Planning Application P/128/25/HH ; 5 Downlands Close, Pagham, PO213QA

Mr. & Mrs. Leadston
 5 Downlands Close, Pagham
 West Sussex PO21 3QA
PROPOSED ELEVATIONS
 A3 PAPER
 Date: Aug. 2025 Scale 1:100 Dwg.no. PR.EL. 01

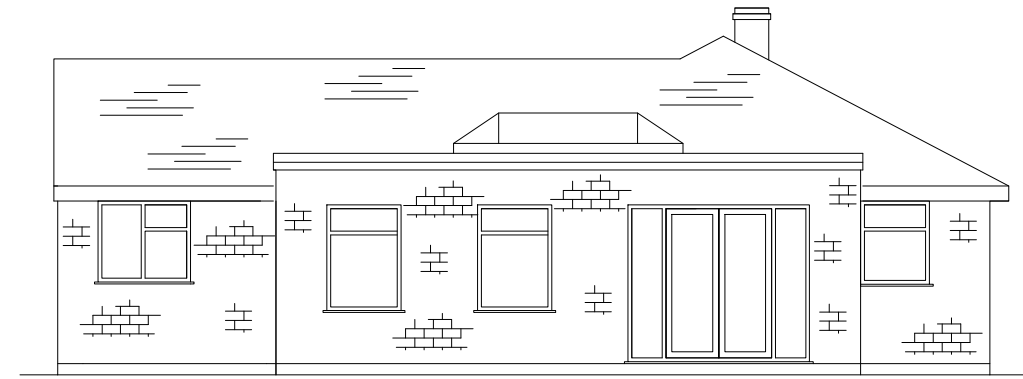
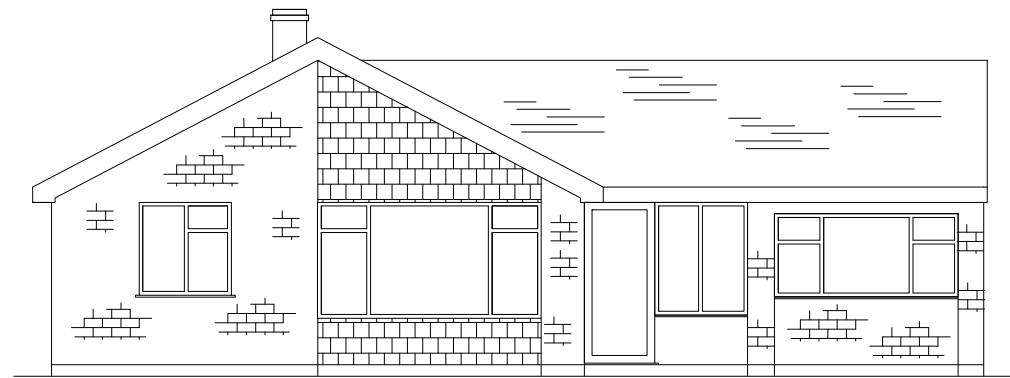
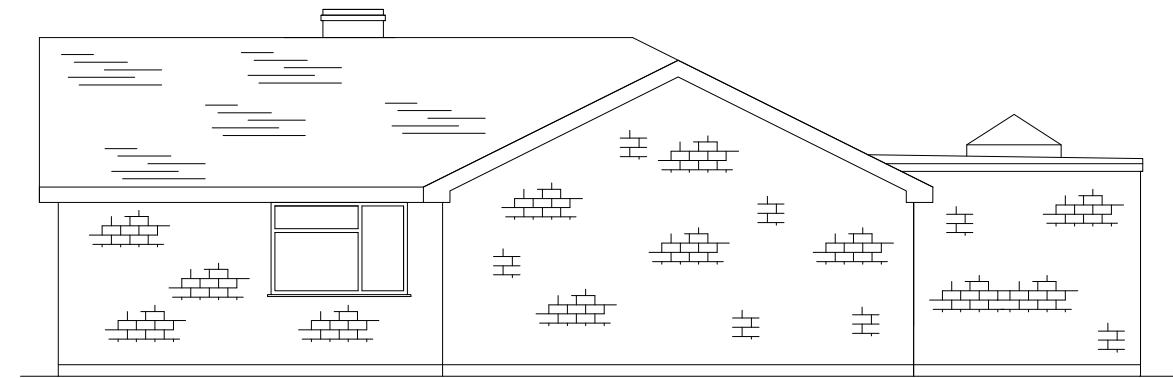
My concerns relate to the closeness of the extension proposed to the boundary and thus to our property and the fact that the property and the extension is at a higher level than our property which means the windows will look down on and over our living rooms.

This can be reduced or prevented by lowering the window and door heights of the new extension and ensuring the window and door pattern will always remain the same. This may however be inappropriate and cause the applicant excess difficulty. Therefore a solution will be to maintain a solid and continuous screen at the boundary of sufficient height to prevent the oversight of our living spaces.
